KIRKLEES METROPOLITAN COUNCIL INVESTMENT & REGENERATION SERVICE

DELEGATED DECISION TO DETERMINE PLANNING APPLICATIONS

Reference No:	2023/62/91442/E
Site Address:	35, Halifax House, Cullingworth Street, Dewsbury, WF13 4AN
Description:	Change of use and alterations to first floor 2 storey flat to create 2 flats
Recommending Officer:	Nina Sayers

DECISION – CONDITIONAL FULL PERMISSION

FIRST FLOOR PLAN
AS PROPOSED
scale 1:100

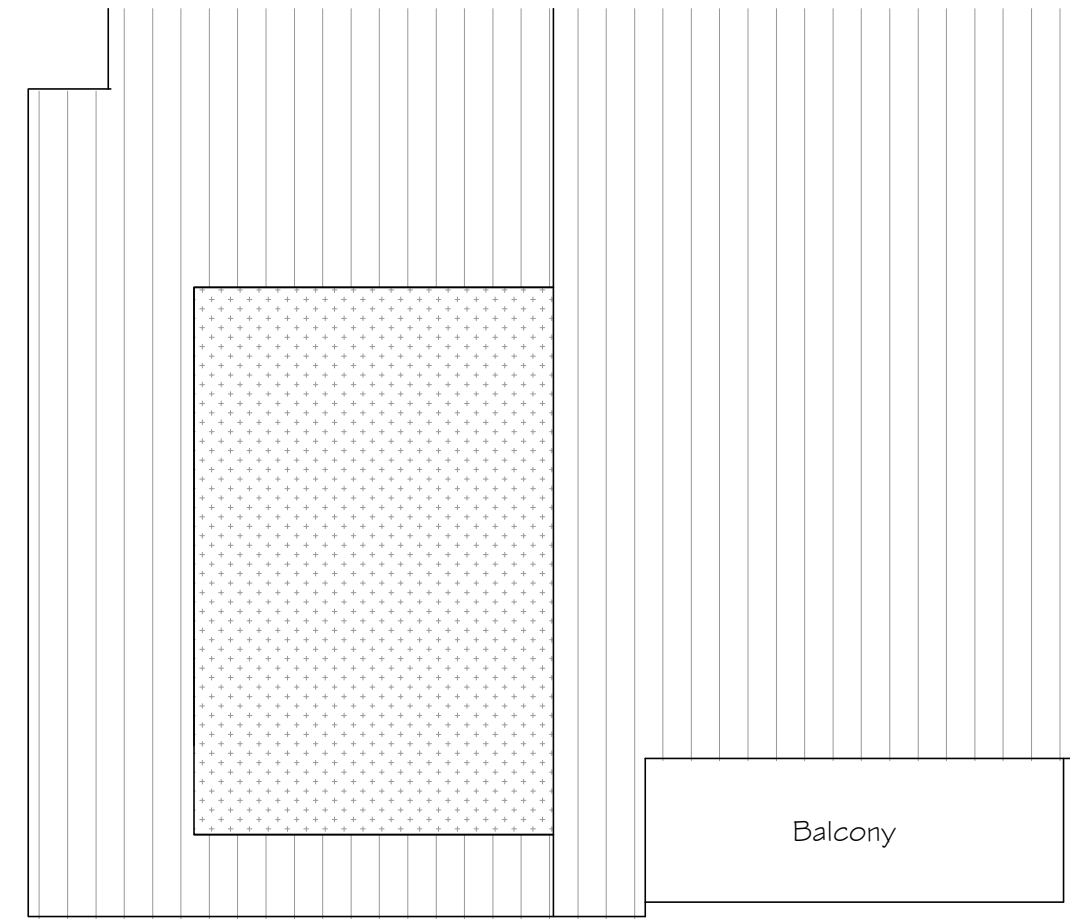
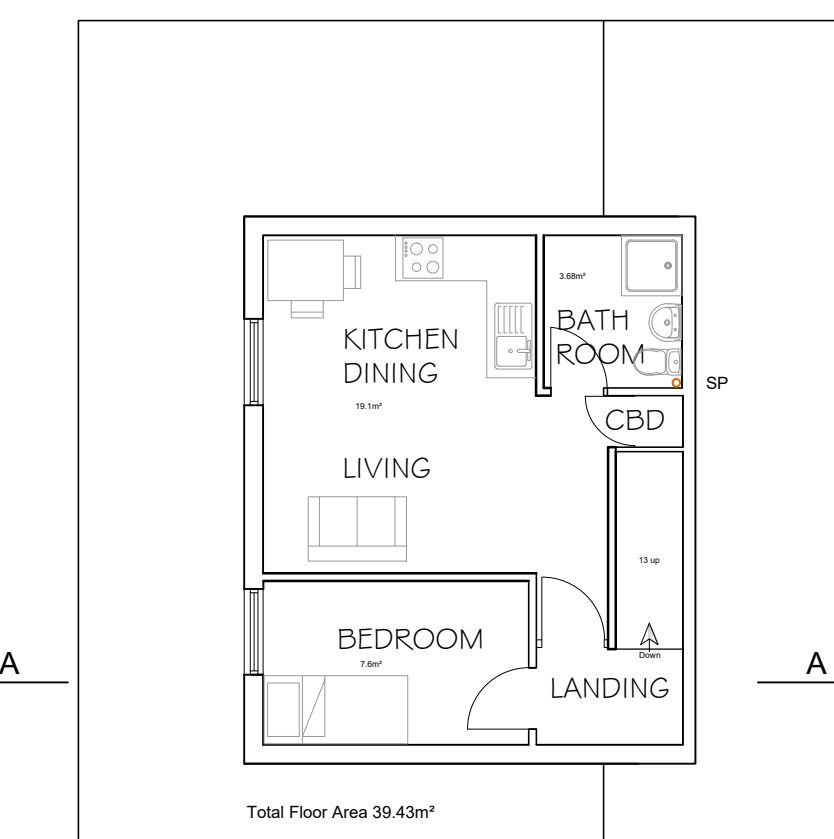
Officers raised concerns regarding the proposed floor area, and failure to comply with the Nationally Described Space Standards. Amended plans were received from the agent and these were considered acceptable in this instance.

Initially the proposed development did not meet the minimum recommendations, as set out within the Nationally Described Space Standards (NDSS), for either dwelling. Officers raised this with the agent who provided amended plans which reduced the number persons per dwelling.

The proposed first floor flat has been re-designed to serve a one-bedroom, two-person dwelling and therefore it meets the minimum recommendations as set out within the NDSS for such a dwelling. The second floor flat has been re-designed to serve a one-bedroom, one-person dwelling and meets the minimum recommendations as set out within the NDSS. There would be sufficient openings to all inhabited spaces allowing for outlook and natural light. It is noted that there is limited amenity space, however the first floor flat does have a balcony area. Given the proposal is within a residential block of flats and is a replacement for a dwelling with more bedrooms, it is considered that this would not cause any additional harm over and above the existing arrangement.
